Agency Review Comments

Sterling Recycling Facility (concrete & Asphalt)

PPR2241

SITE DEVELOPMENT PLAN

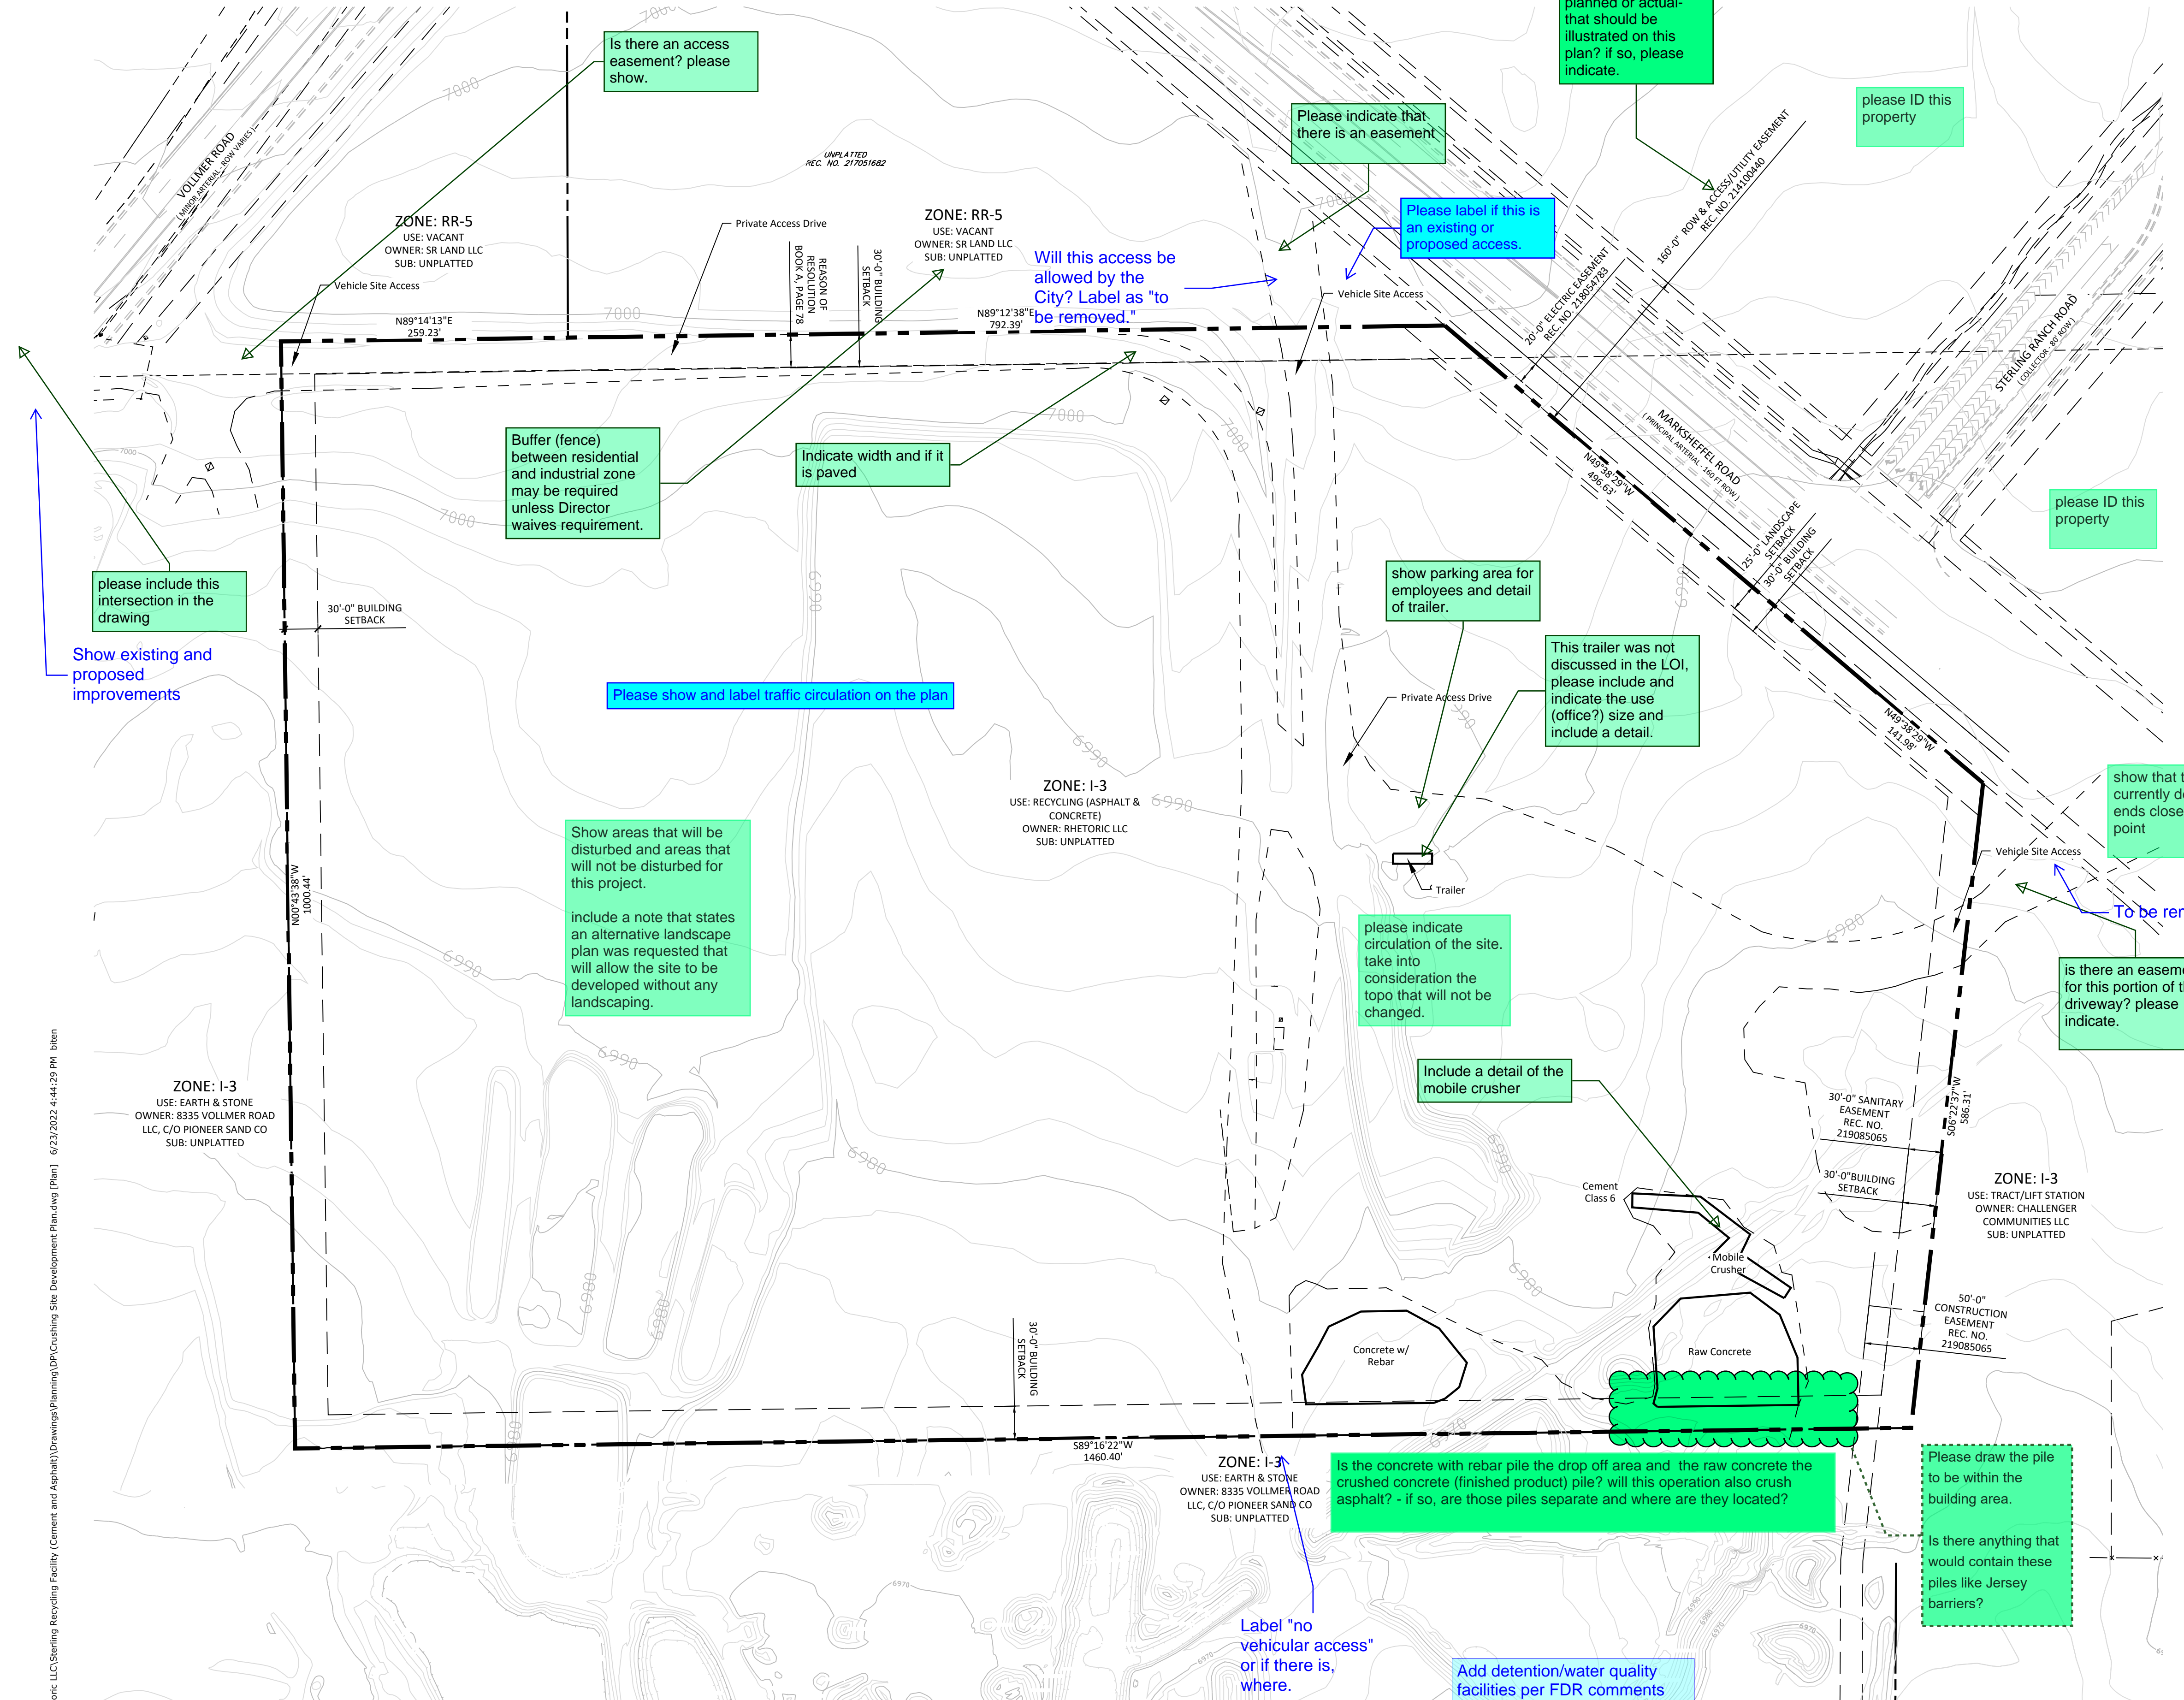
| PCD Project Manager | site dev. plan | 8/2/2022 12:38:27 PM |

**VOLLMER ROAD  
INTERSECTION AT MARKSHEFFEL ROAD DETAIL**

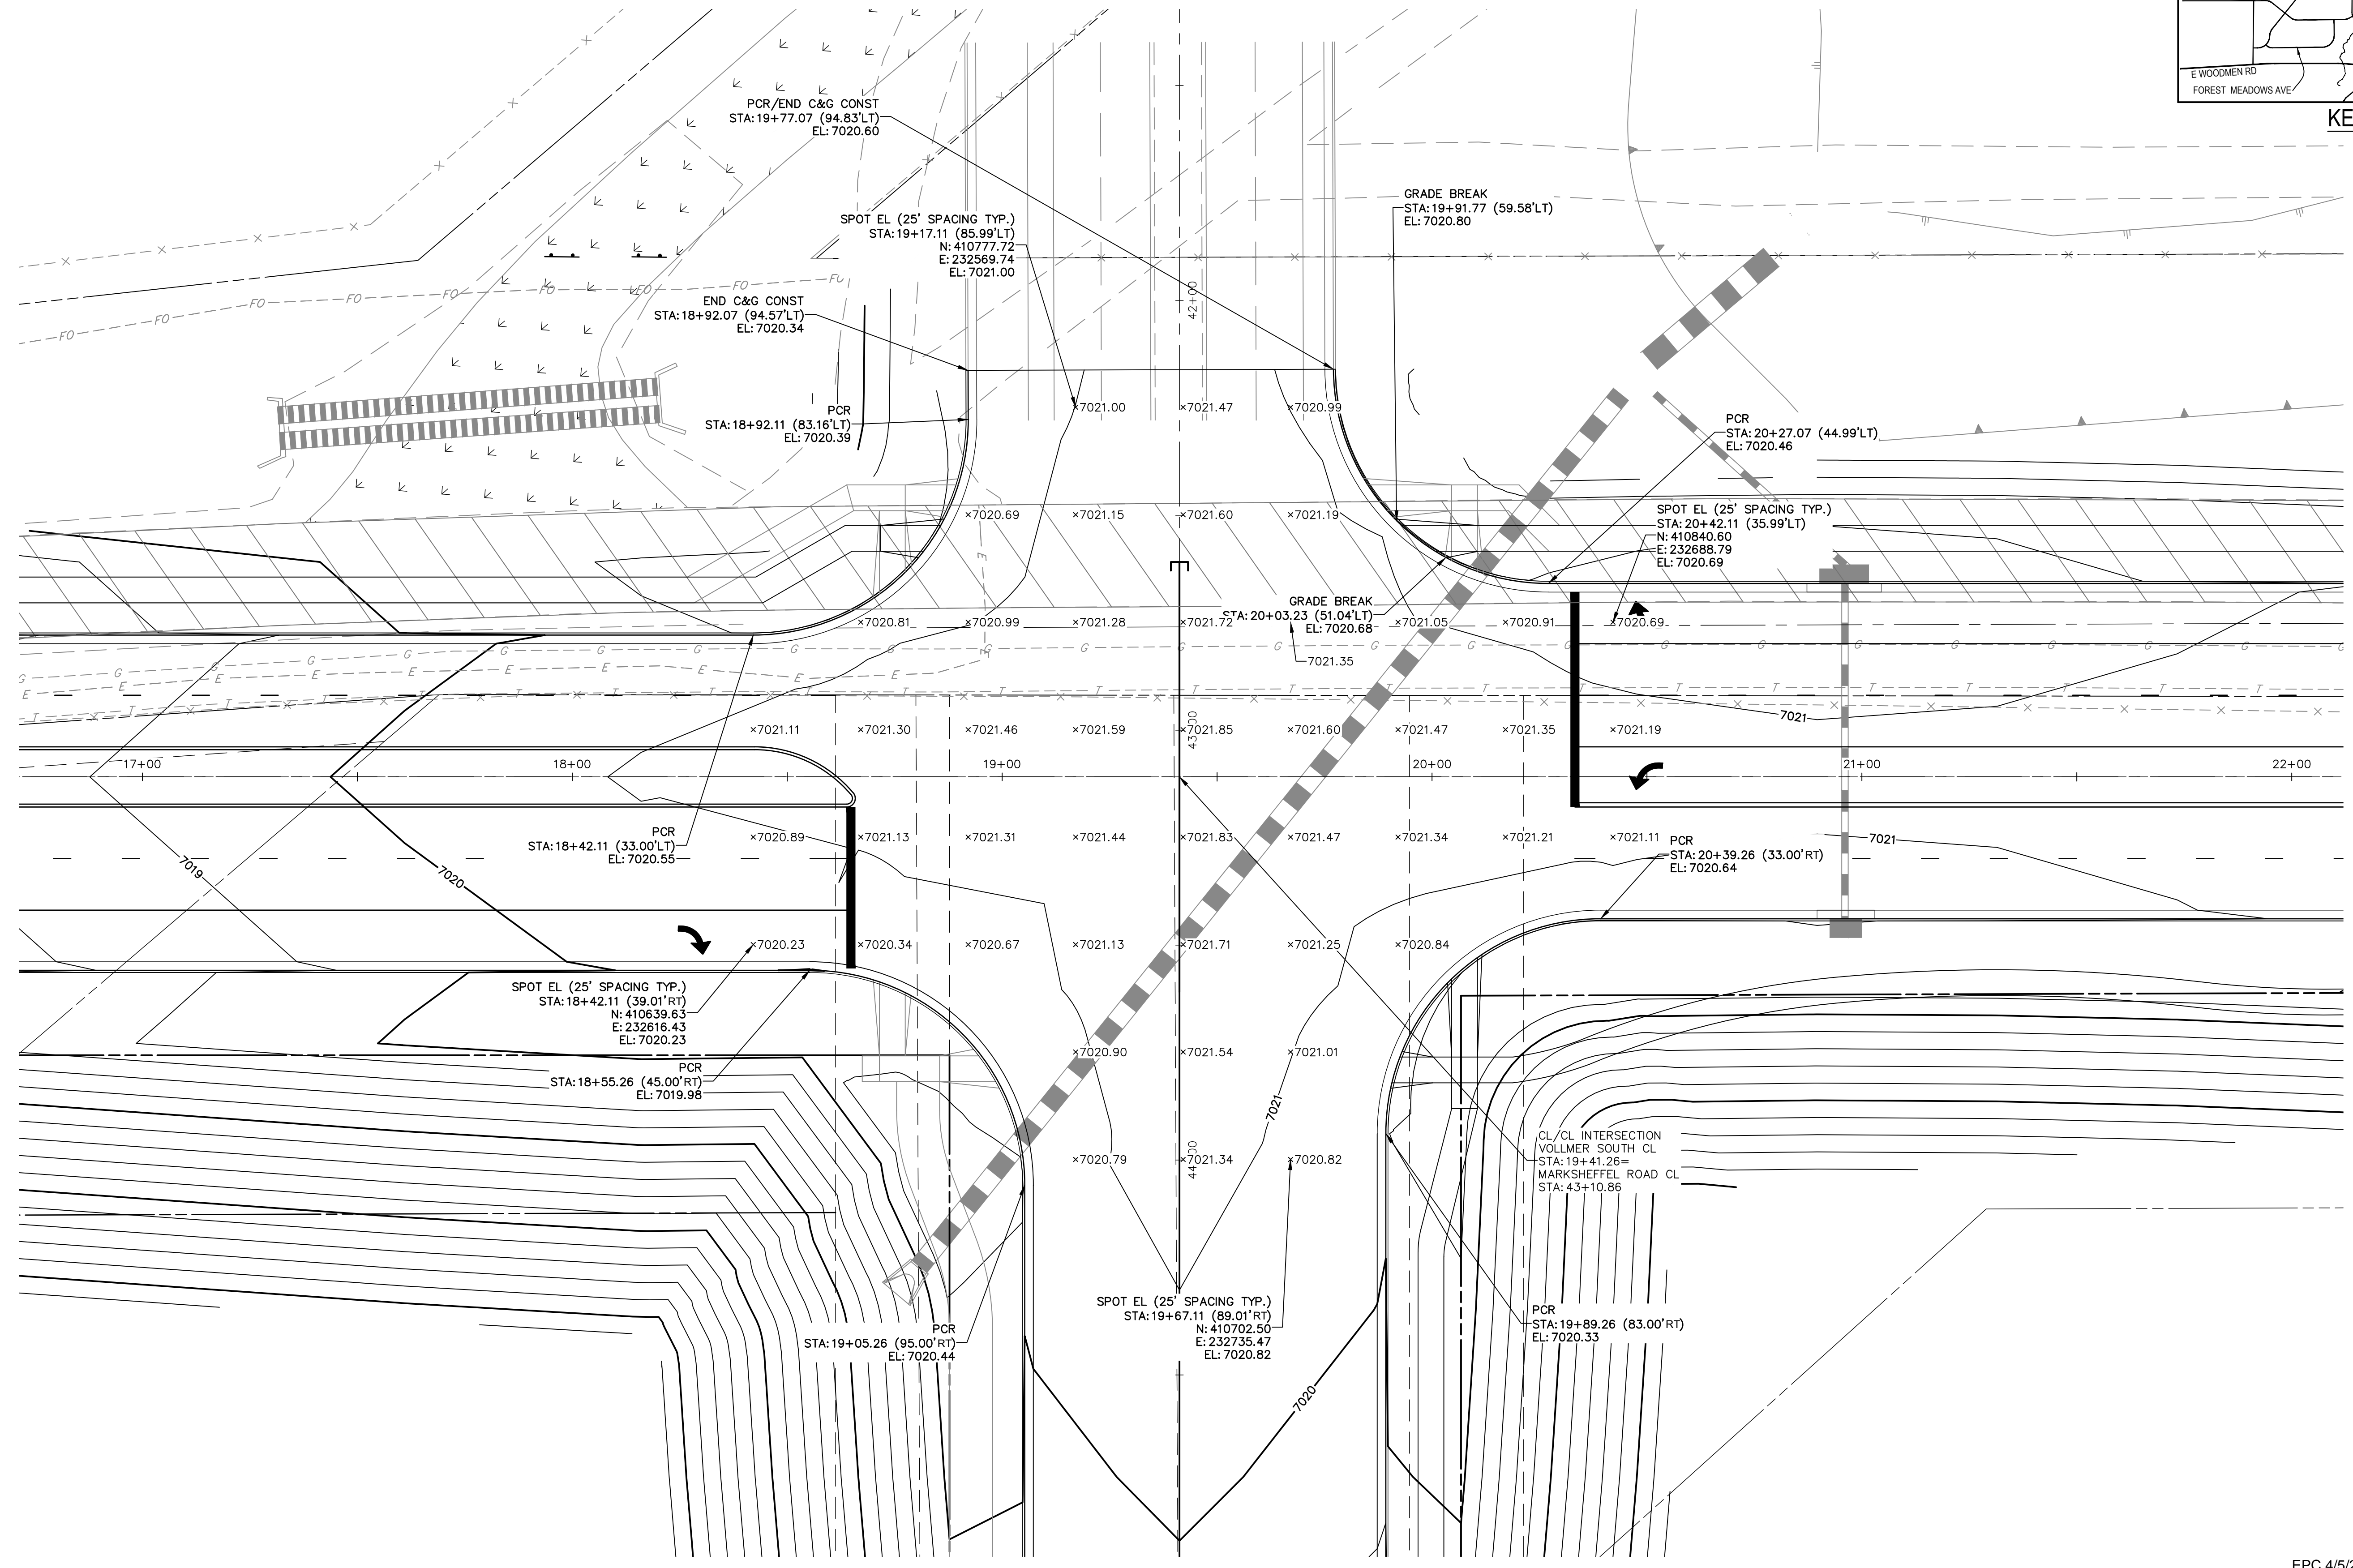
| Colorado Springs Public Works | <p>- Since Marksheffel Rd. will be owned and maintained by the City of Colorado Springs, public improvements are required. Add a note and show the required 10' trail adjacent to this site along Marksheffel (as shown on the construction plans, approved 7-22-21), Call out who will be responsible for building the trail and when this will occur.</p> <p>- To meet Minor Arterial standards, install a 10' detached sidewalk adjacent to Vollmer next to this property and Type 1 curb/gutter. Submit separate construction plans to the City for these public improvements, in addition to the proposed access point along Vollmer.</p> | 8/2/2022 9:40:26 AM |

| | <p>Joel Dagnillo, P.E. Engineer III Engineering Development Review City of Colorado Springs (719)385-5412 Joel.dagnillo@coloradosprings.gov</p> | <p>JR Response: improvements along Vollmer are not triggered by this development</p> |
